FINAL PLAT

ROMENS SUBDIVISION

A PORTION OF THE NORTHEAST QUARTER OF THE NORTHEAST QUARTER OF SECTION 24, TOWNSHIP 11 SOUTH, RANGE 64 WEST OF THE 6TH P.M. COUNTY OF EL PASO, STATE OF COLORADO

BARRON LAND
BOUNDARY & MAPPING & SURVEYING & CONSTRUCTION
2790 N. Academy Blvd., Suite 311 P: 719.360.6827
Colorado Springs, CO 80917 F: 719.466.6527
www.BARRONLAND.com
PROJECT No.: 20-010 SHEET 1 OF 2

## FINAL PLAT

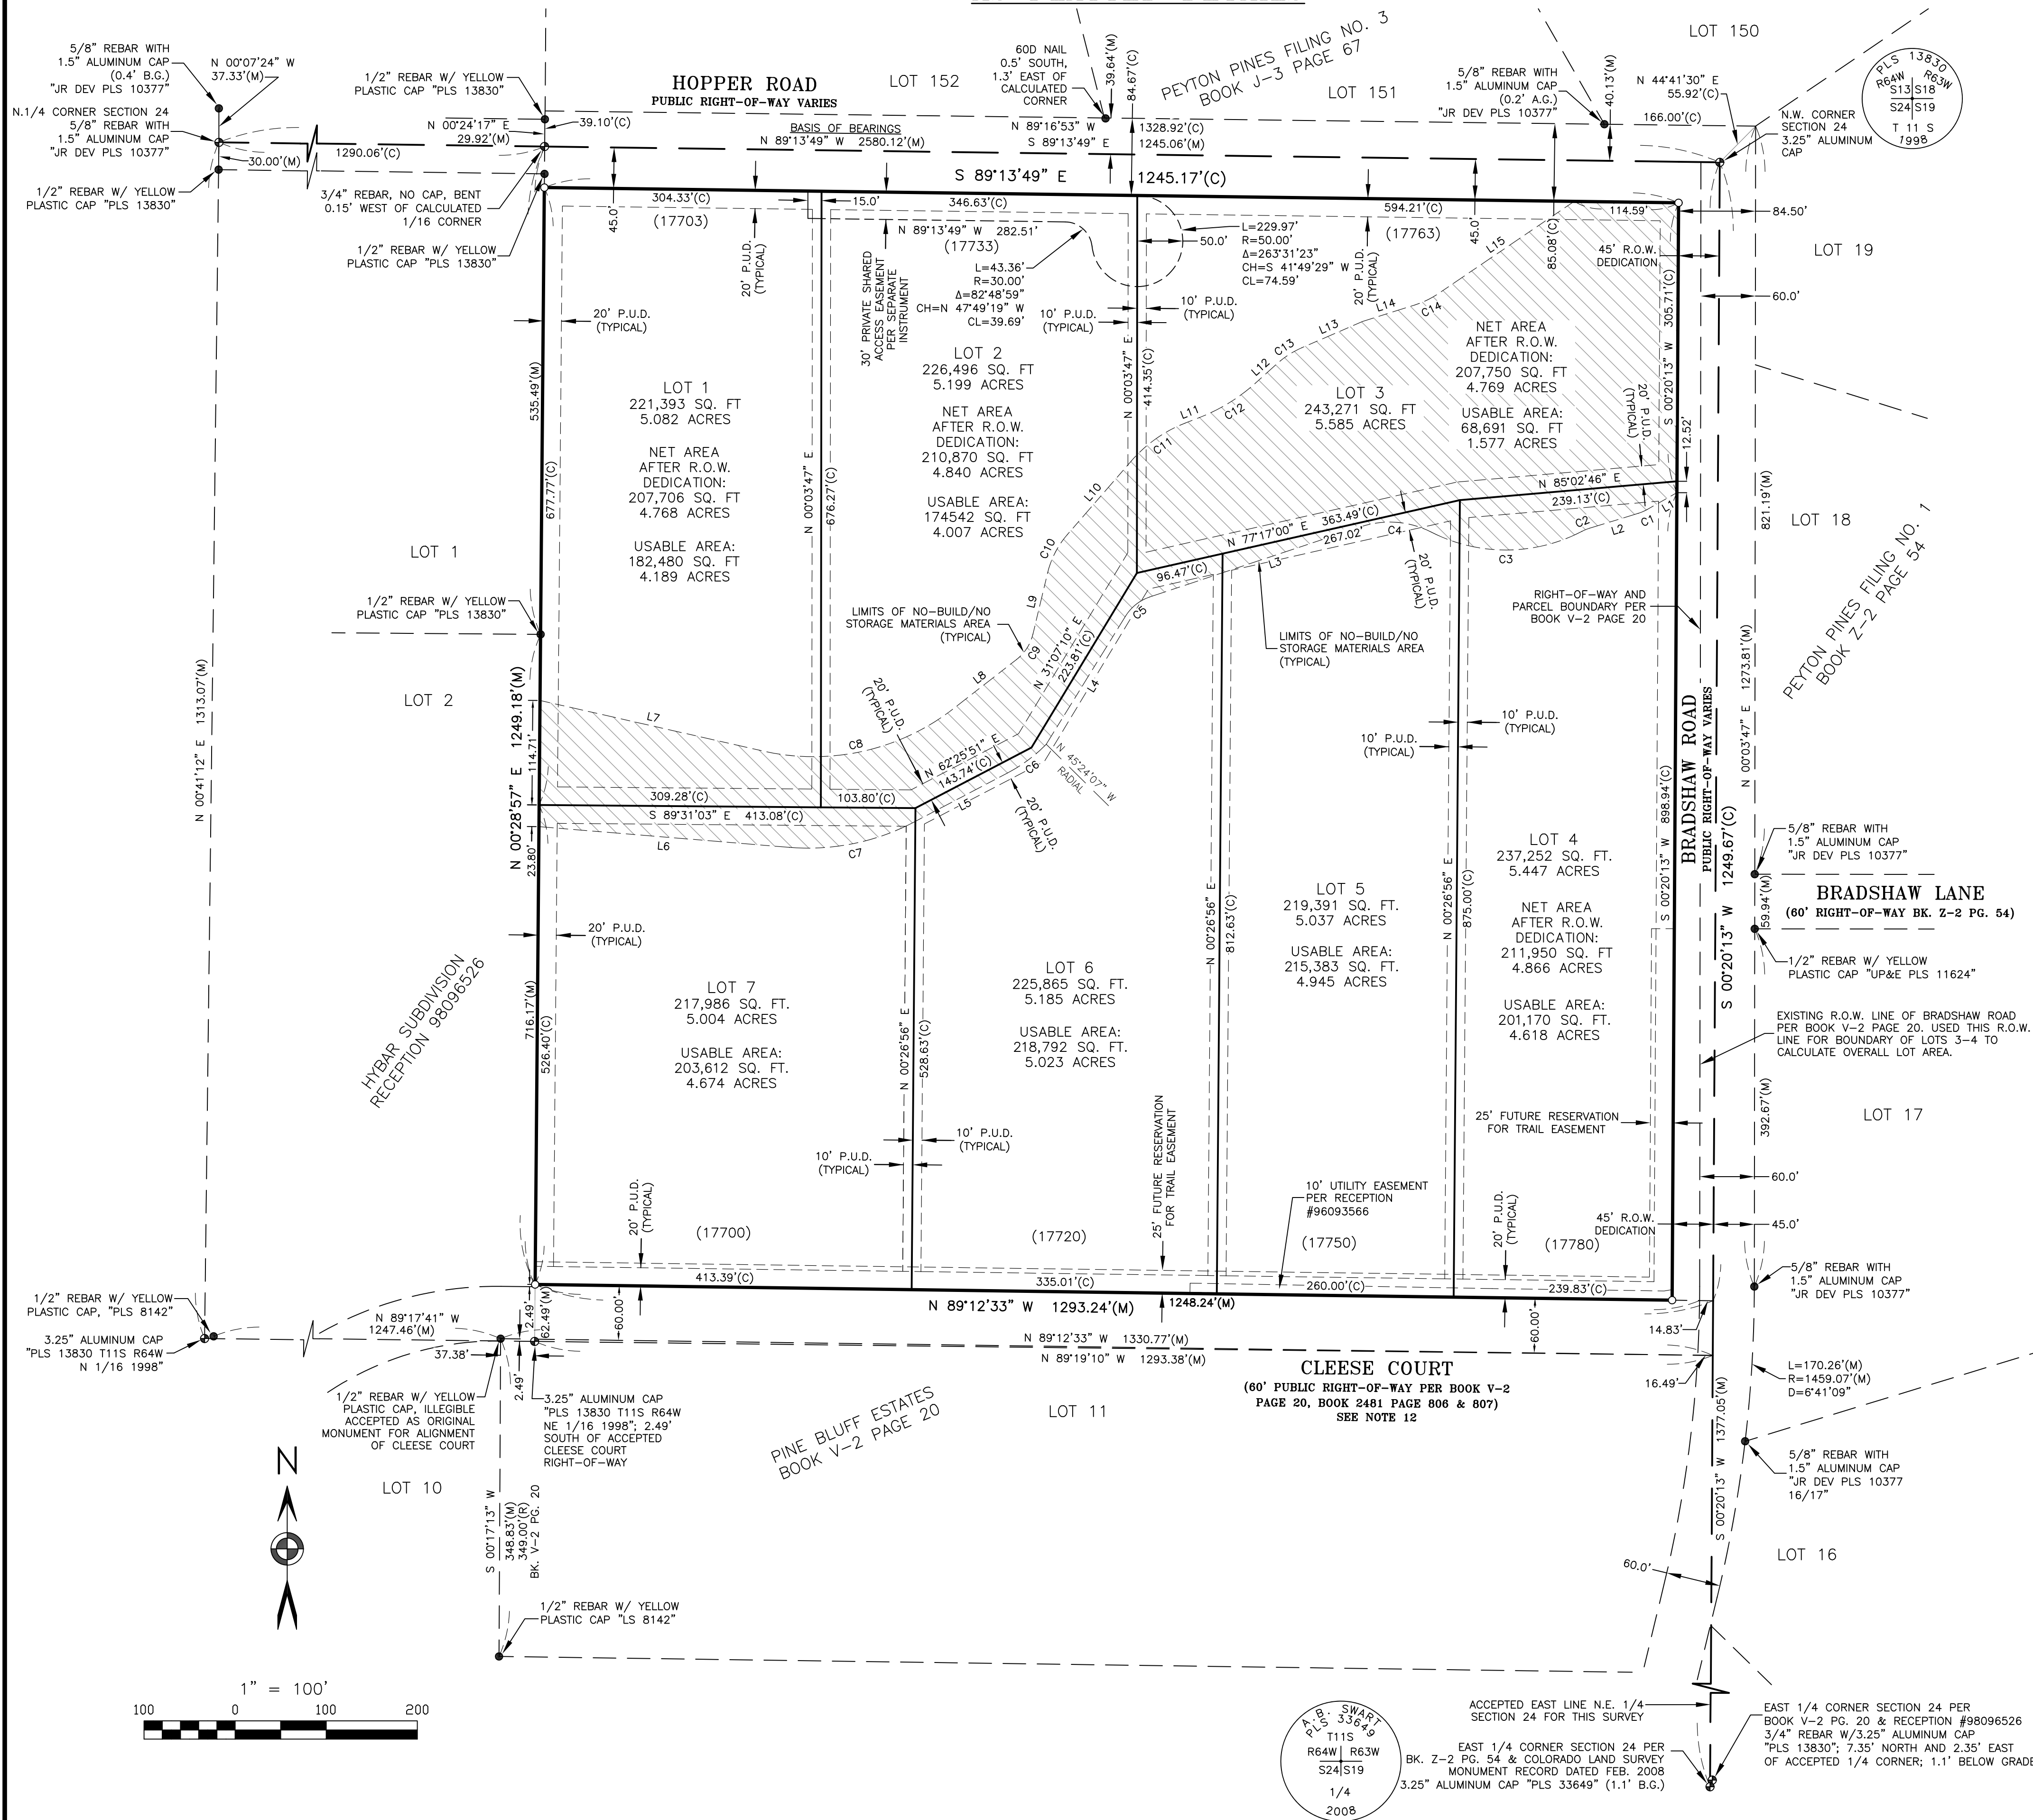
point of beginning
needs to be labeled.

Per MVEA
comments: make
sure there is a 10' rear
lot utility easement +
20' exterior utility
easement on plat.

Plat existing facilities with easement on plat.
+ other comments.

Adjust access easement to a reasonable alignment across the drainage way in lieu of the two 90 degree bends.

Revise easement width. It seems more appropriate to identify a 30' wide easement to allow for shoulders and space to construct if the minimum width of 2-way driveway is 24 ft. See Land Development Code Section 6.3.3.C.3.
